Please Quote 21837634
14 January 2016

Your ref: MO 09_0121 MOD 1

PROPOSAL: Modification of consent for approved mixed residential & commercial premises 7 stories

PROPERTY: Lots 11 - 116 DP 10650, Nos 47 – 50 The Esplanade, Ettalong Beach

1 LEVEL 3 FLOOR PLAN

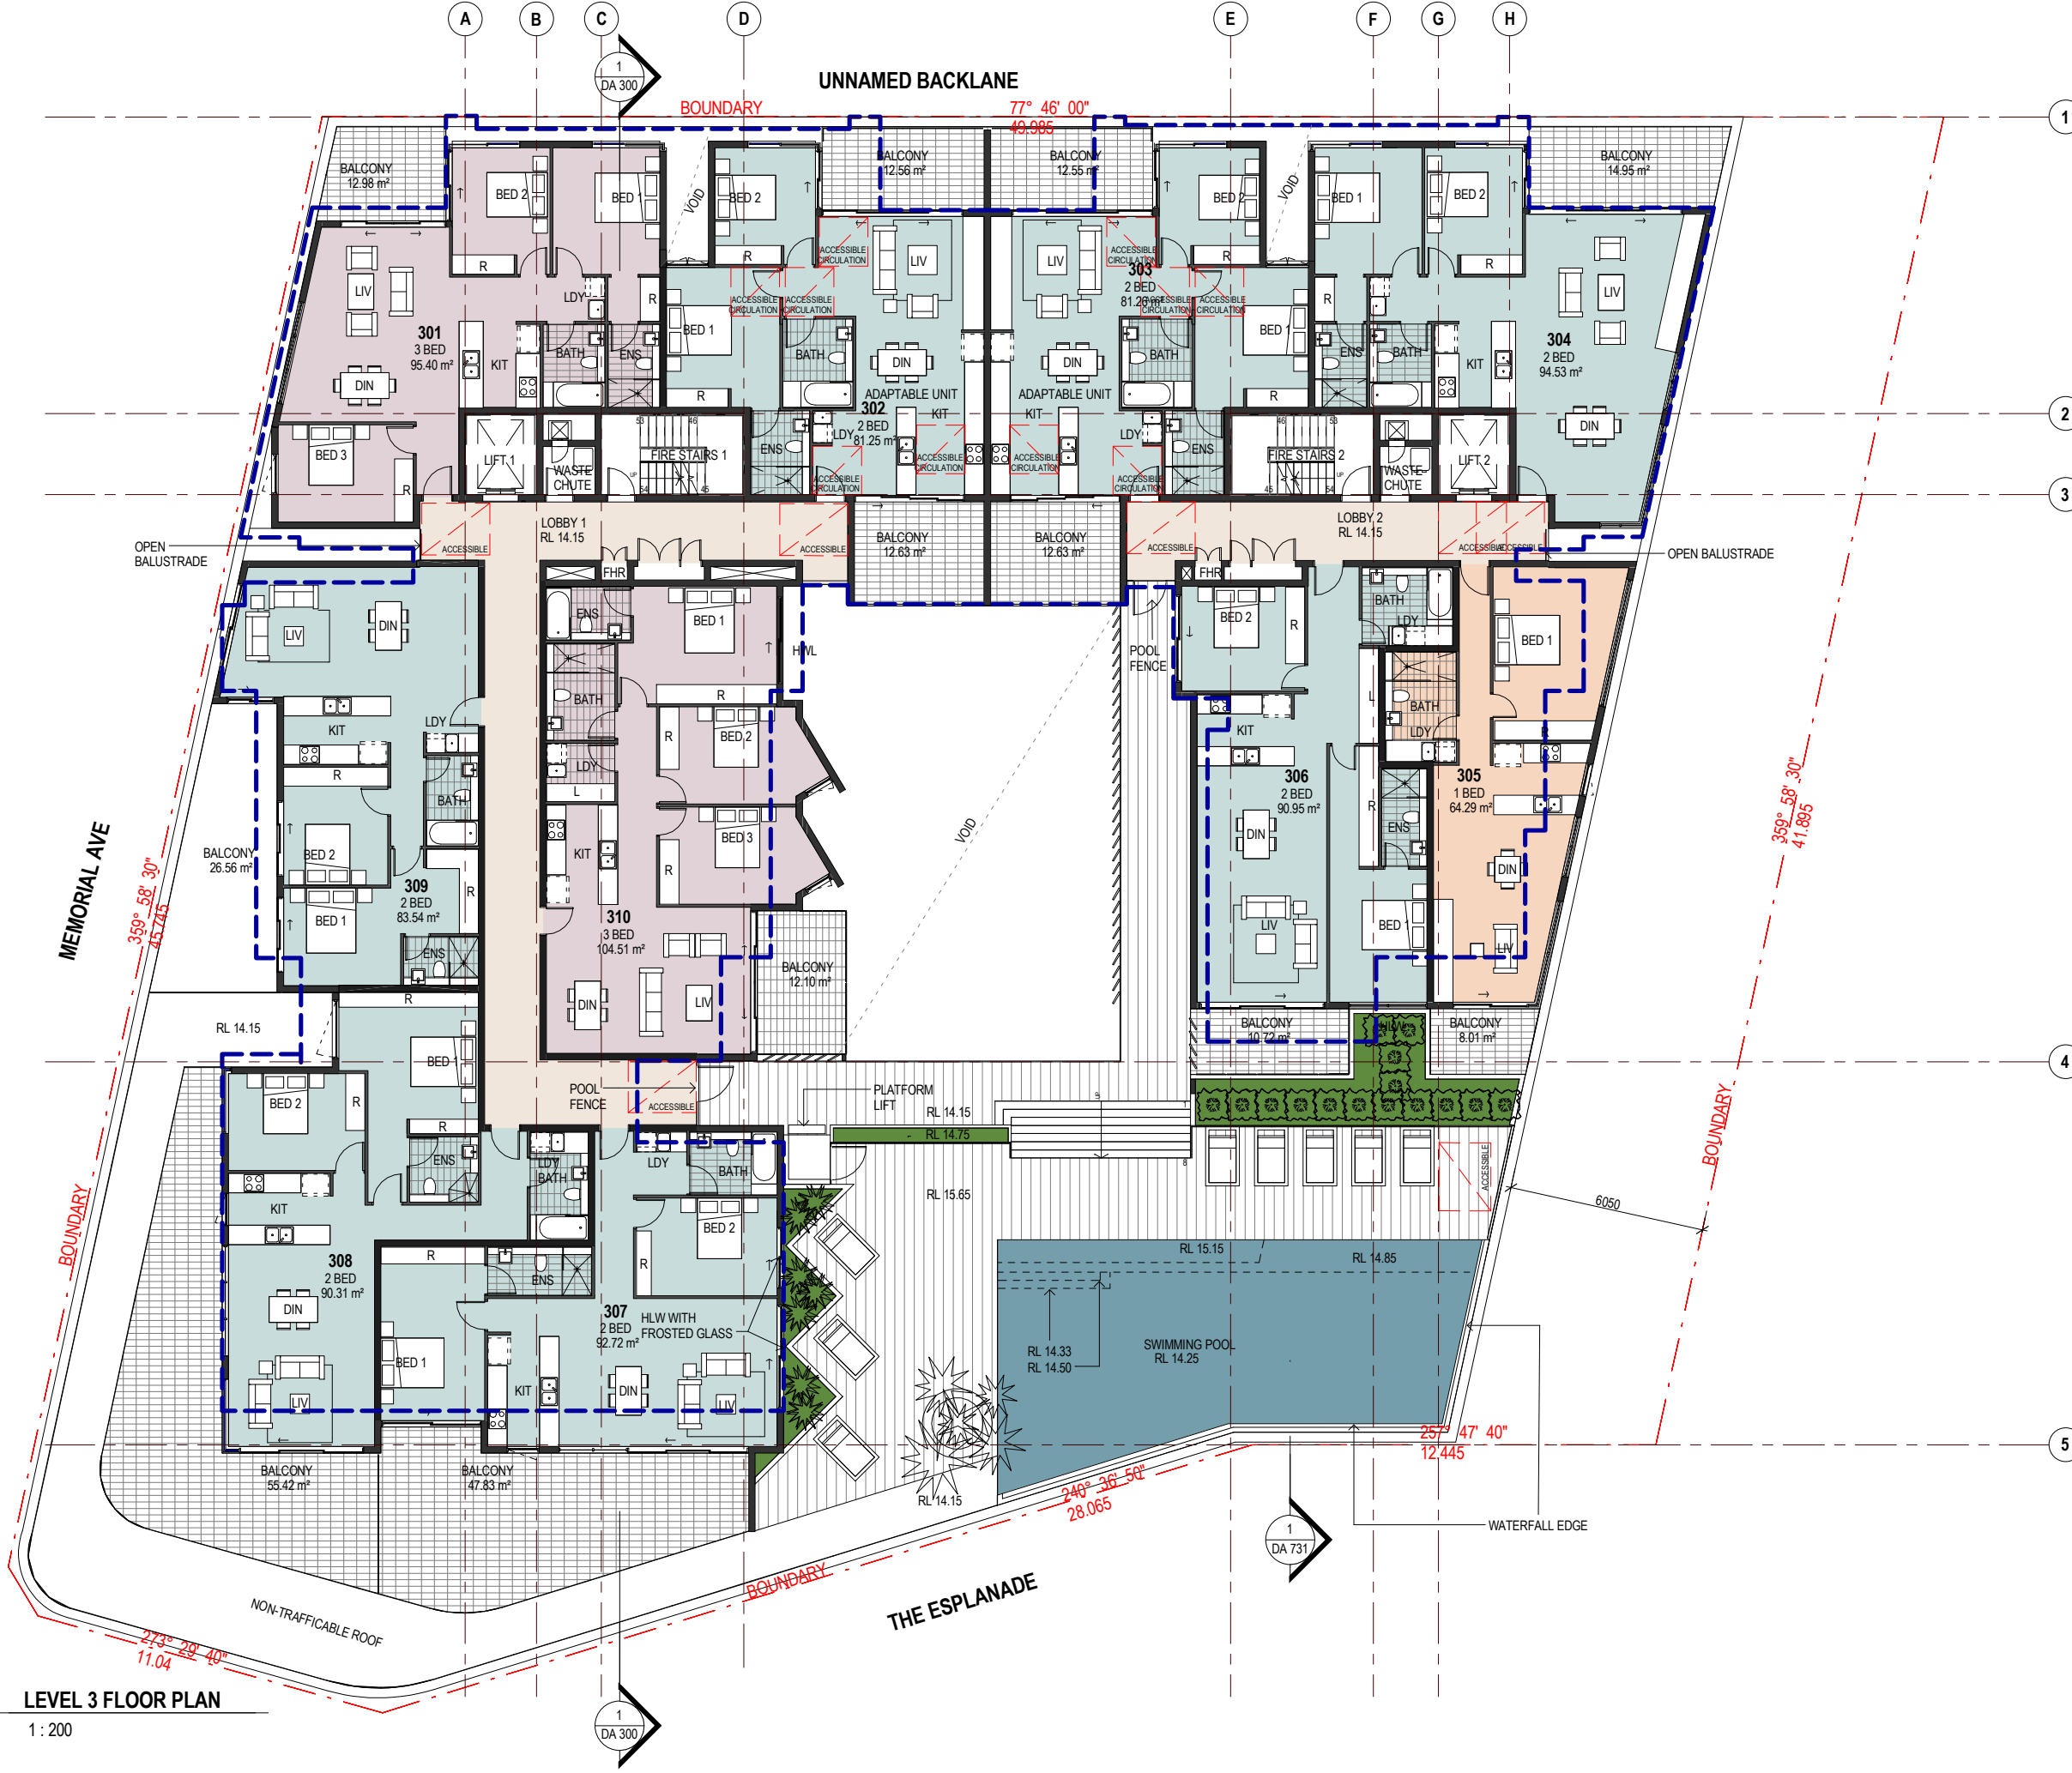
- There is concern at the inadequate solar access, privacy conflicts and poor outlook of the internal units (115, 215 and 310). These do not comply with separation distances in the Apartment Design Guide (ADG) and rely on screens to attempt to provide visual privacy. These may provide some visual privacy but do not ensure acoustic privacy and reduce outlook and solar access. A preferable option would be to remove these three units and incorporate the floor area into adjacent units and/or for landscaping and common facilities such as a meeting room or gym.

01 North Elevation 1:200@A1

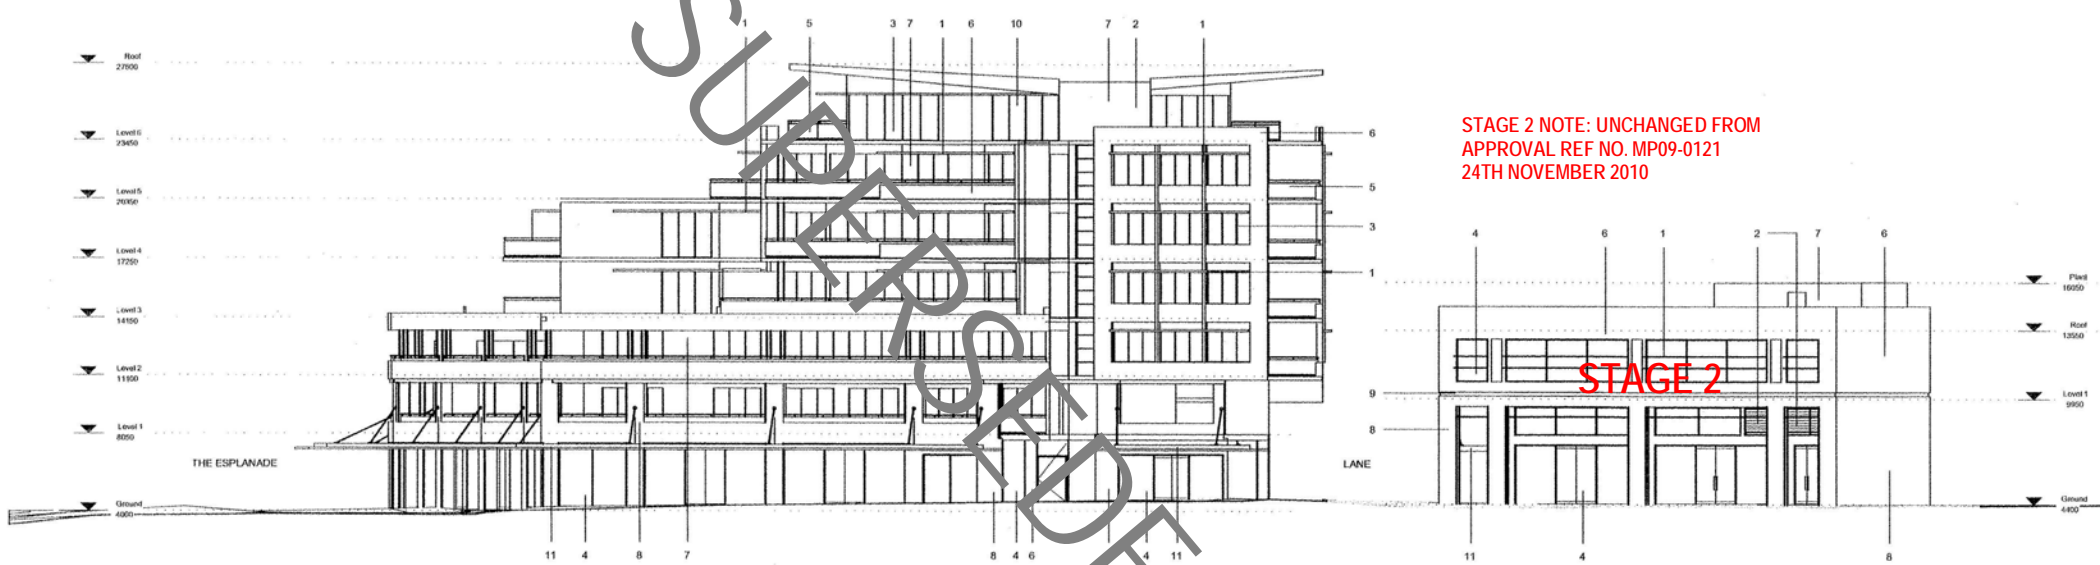
- The laneway on the north of the site is part of the public domain and the building should address the street in a more appropriate manner than blank walls and roller shutters. The building above should be setback in some locations to allow for adequate landscaping to contribute to the streetscape and provide a visual connection between Memorial Avenue and the new pedestrian lane.

- The curved slab edges emphasise the prominent corner and emphasise the podium level and add definition to the street front with upper levels stepping back to reduce the scale.
- There remains concern that the northern elevation facing the lane is composed entirely of blank walls, roller shutters and doors. This should be amended to include some areas of landscaping to contribute to the streetscape and soften the appearance of the blank walls.
